Rezoning Transportation Analysis

Petition Number: 2020-054

General Location Identifier: Tax ID 14525501

Revision Log:	Date	Description
	05-18-20	First Review

**TECHNICAL DATA SHEET**

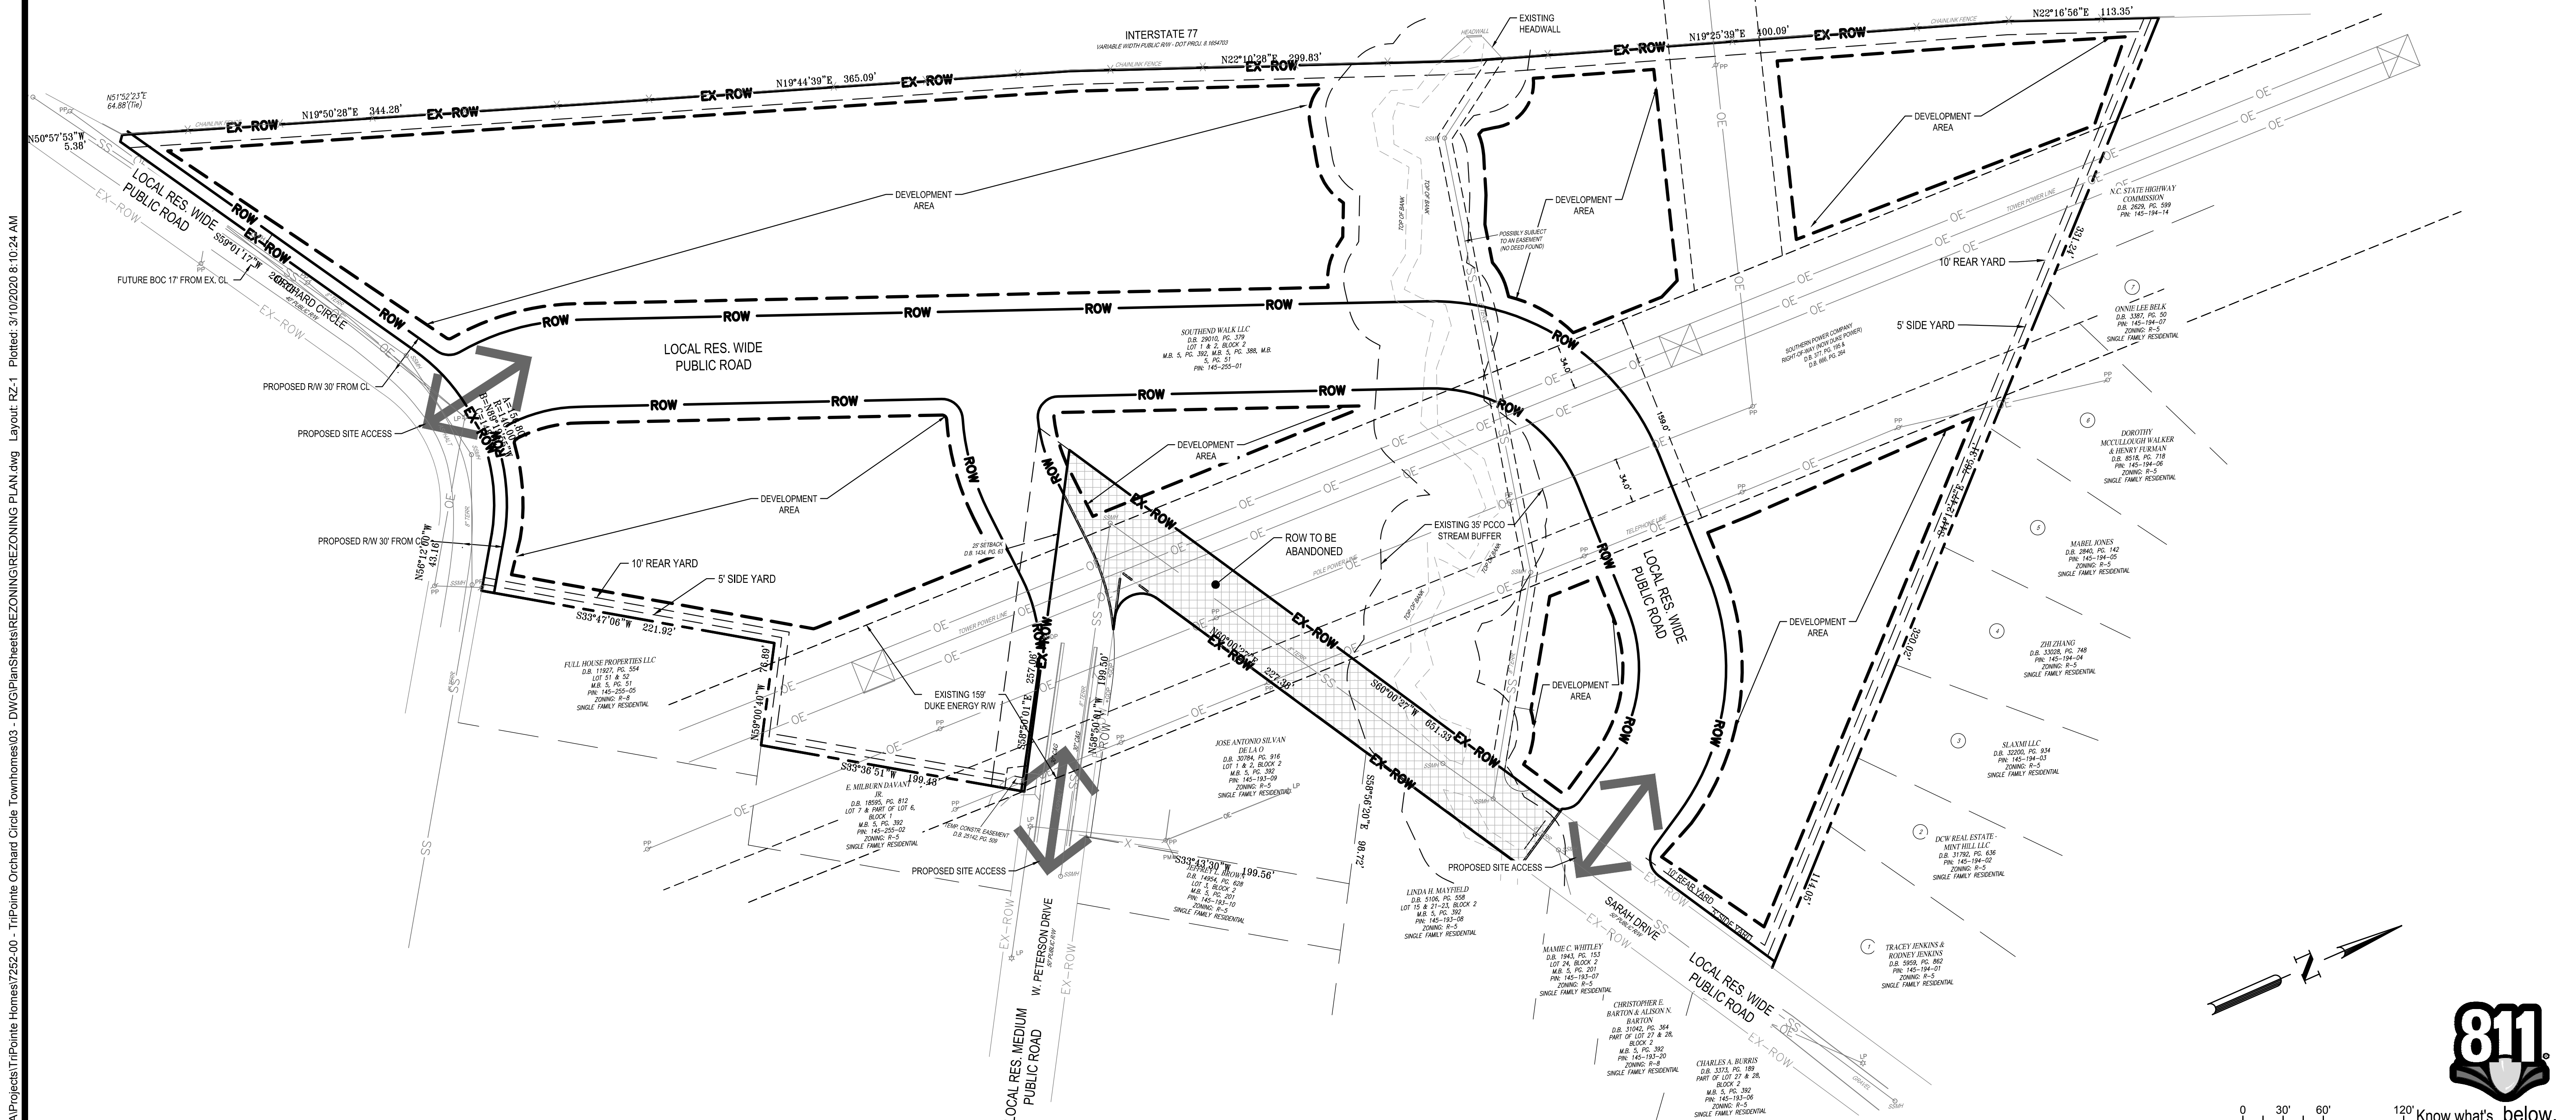
5. The petitioner should revise the site plan and conditional note (Section III.4) specifying dedication and fee simple conveyance of all rights of way to the City before the site's first building certificate of occupancy is issued. CDOT requests right-of-way or a permanent sidewalk easement set at 2' behind back-of-sidewalk where feasible.

6. The petitioner should revise the site plan and conditional note(s) to commit to posting 25 mph speed limit MUTCD signs on new proposed public streets.

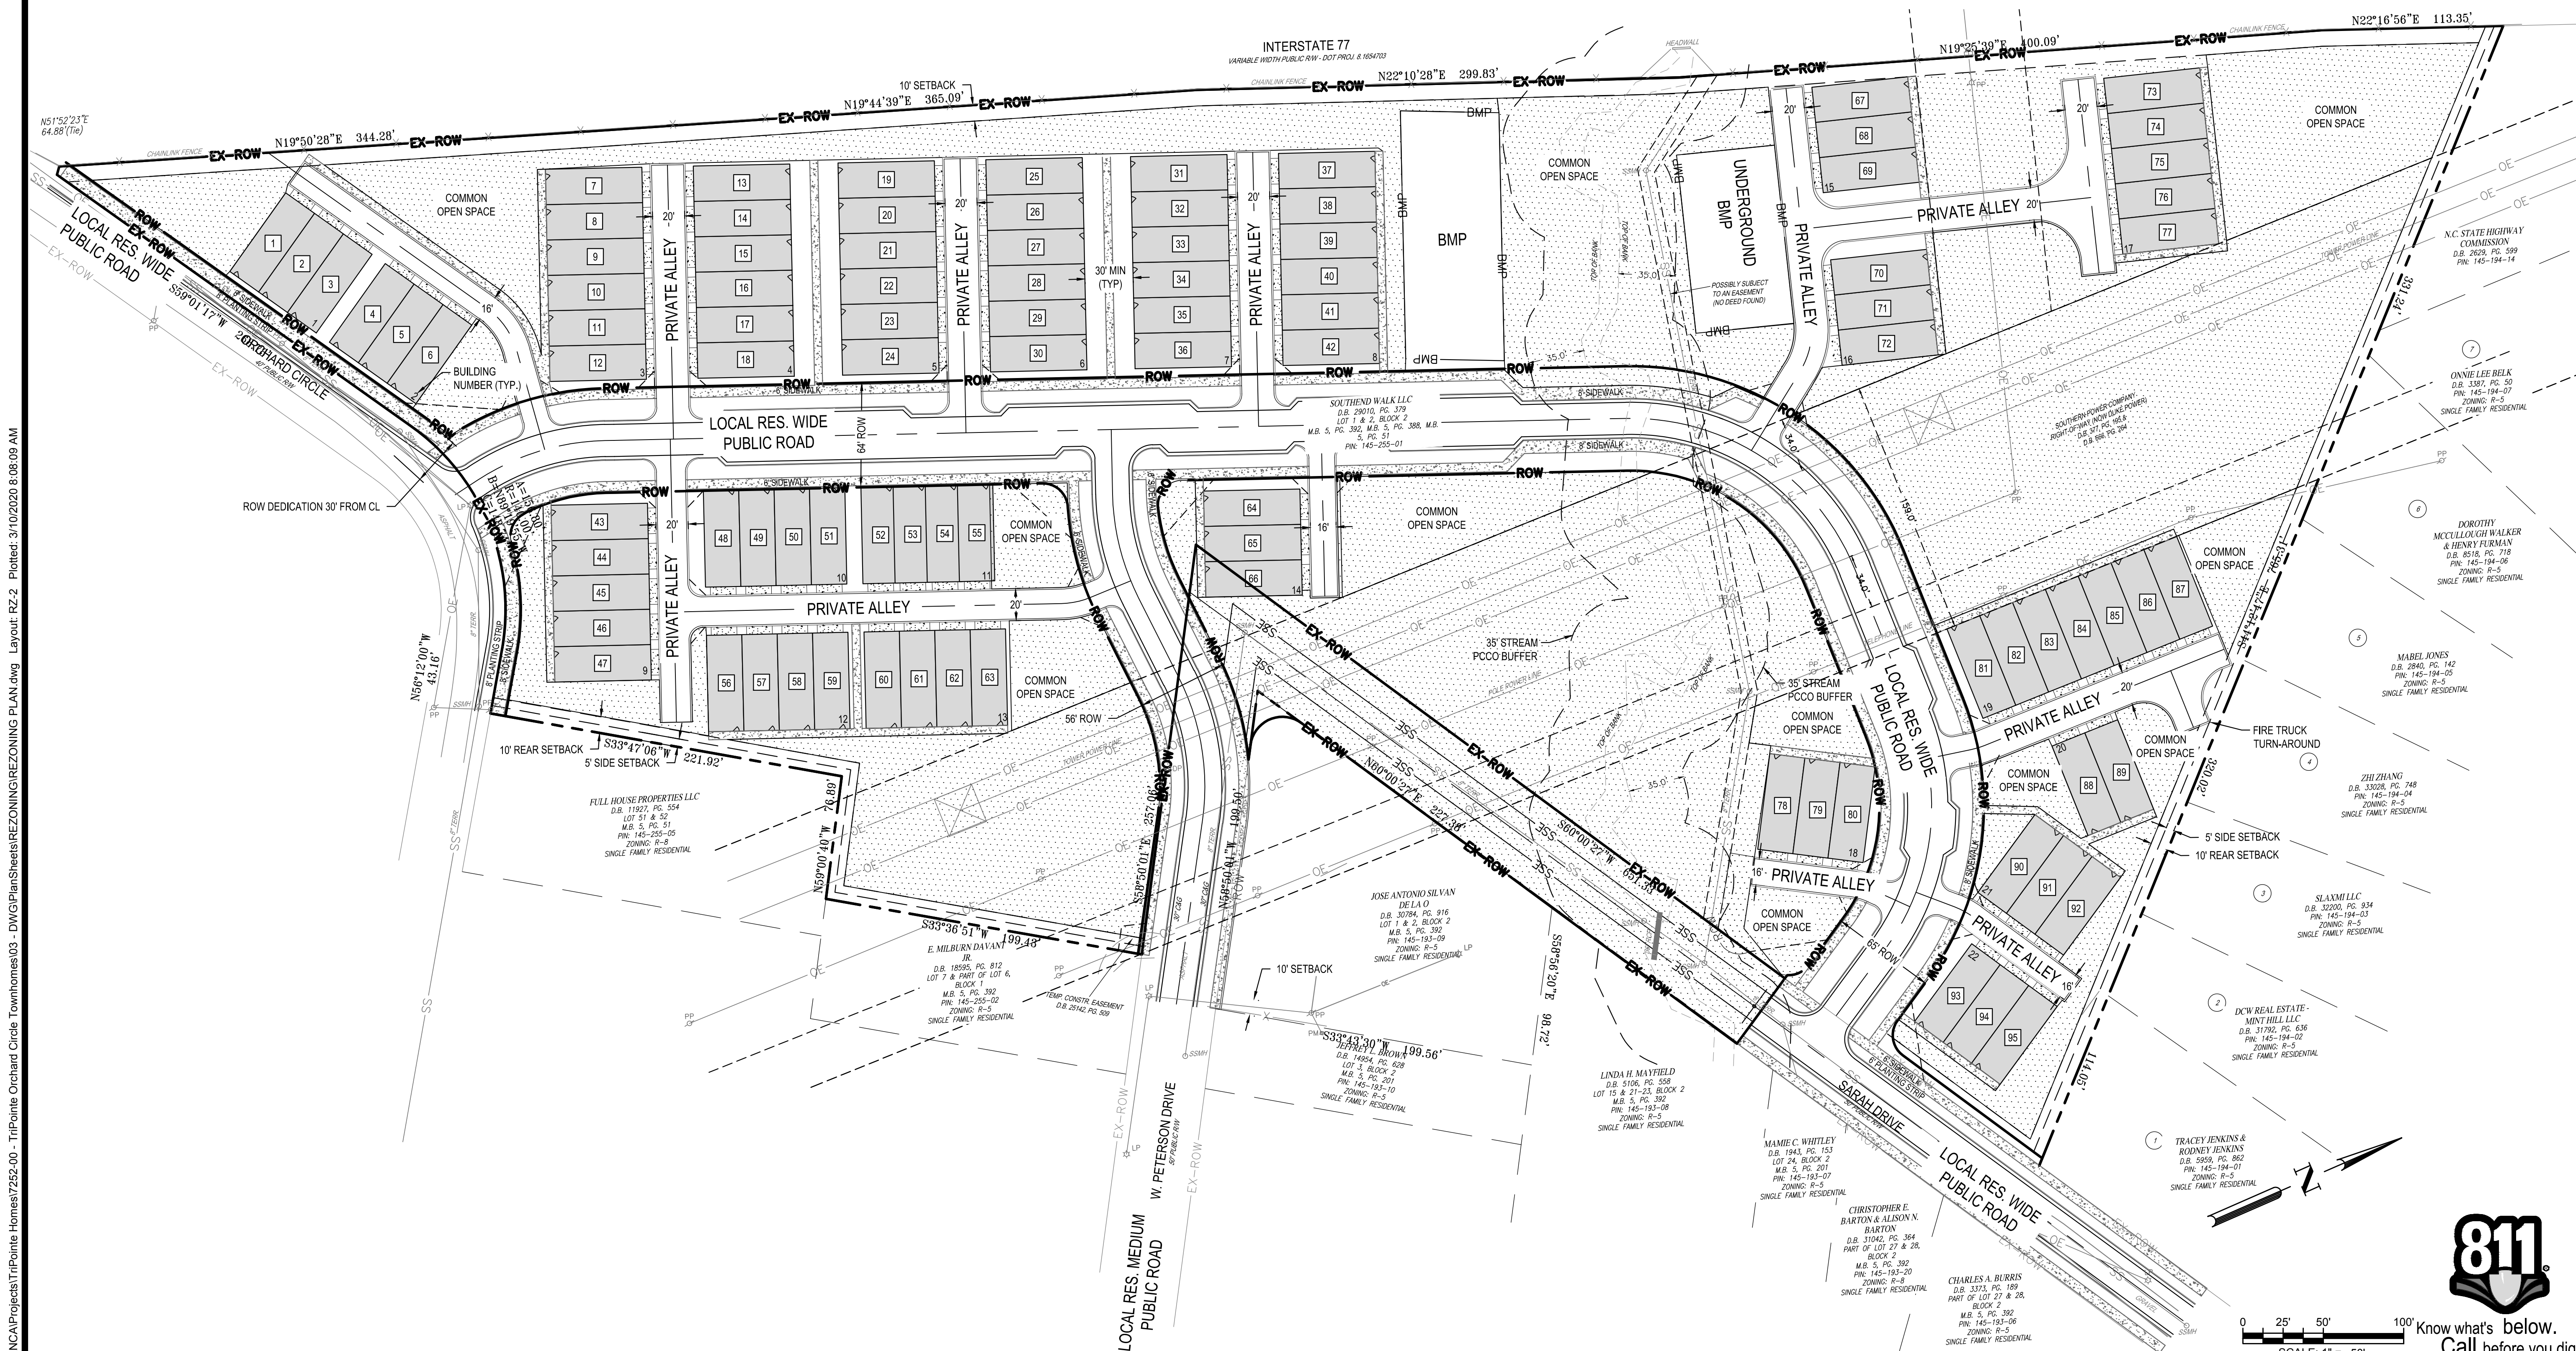
- Curbline** The proposed zoning district has a setback measured from back of the existing or proposed future curbline.
 - Orchard Circle:** Proposed location of curb and gutter is the correct future location.
 - W. Peterson Drive:** Proposed location of curb and gutter is the correct future location.
 - Sarah Drive:** Proposed location of curb and gutter is the correct future location.

The site plan should show the curb and gutter **labeled and dimensioned** from the centerline for each road.

- Traffic Study** A Traffic Impact Study is not necessary for the complete review of this petition.
- The petitioner should revise the site plan and conditional note(s) for the site plan callout "ROW TO BE ABANDONED." A conditional note (Section III.6.) should include "The petitioner should complete and submit the [Right of way Abandonment Petition form](#) to CDOT for review. The decision of this rezoning petition does not correlate with the decision of the possible abandonment, as this decision is issued within the separate Right of Way Abandonment process that is controlled by North Carolina General Statutes. The site plan abandonment call-out should be revised to "Potential Abandonment refer to conditional note (Section III.6)."

4. The petitioner should revise the site plan and conditional note(s) to confirm that there is a minimum of 230 feet of right-of-way is either currently reserved or will be dedicated from centerline for the future I-77 Managed Lanes Project (TIP# I-5718A).

7. The petitioner should include the intersection sight distance in plan view, to confirm that CDOT's Sight Distance Policy requirements will be met at the proposed access on the horizontal curve of Orchard Circle.
